Please ask for: Ms Iqraa Malik
Email: iqraa.malik@terraquest.co.uk
Telephone: 01212341390
Our Ref: LU/342/20/HH
Your Ref:
Date: 22nd December 2020

Application for Planning Permission for Works or Extension to a Dwelling

Development: Conversion of existing dairy building into a new kitchen, internal alterations, a replacement carport and replacement garden fencing
Location: Vine Cottage 1 Church Street Littlehampton BN17 5EL

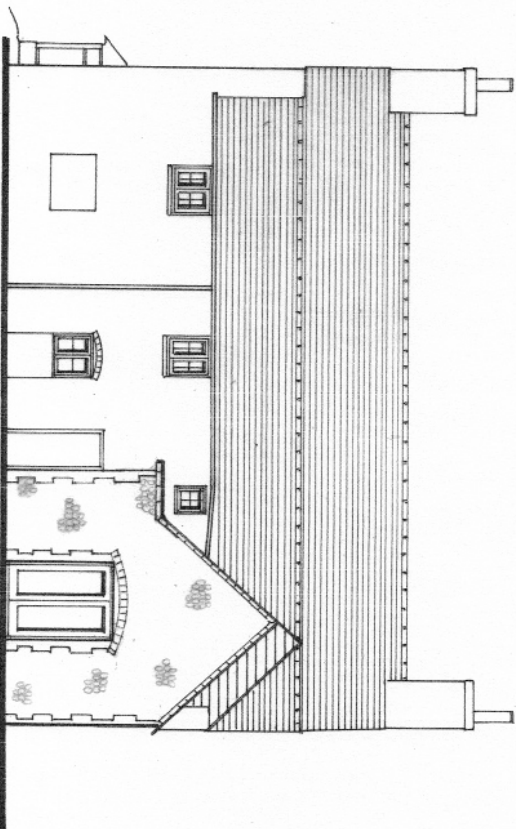
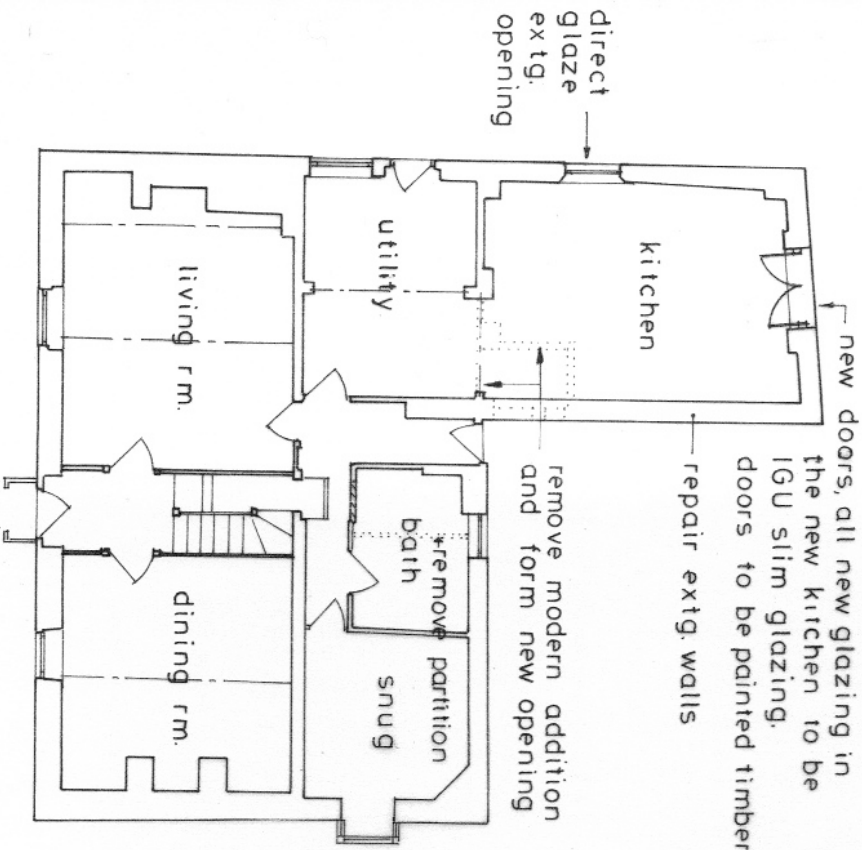
Fence: Please provide elevations of the proposed fence

Confirmation: Please confirm whether the fence is going around the entire site and show the area the fence is going around on the plan

AS PROPOSED

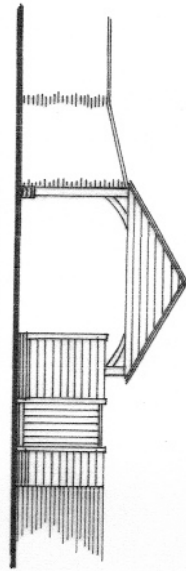
Confirmation Required: Please confirm whether the existing dairy barn is attached to the existing dwelling
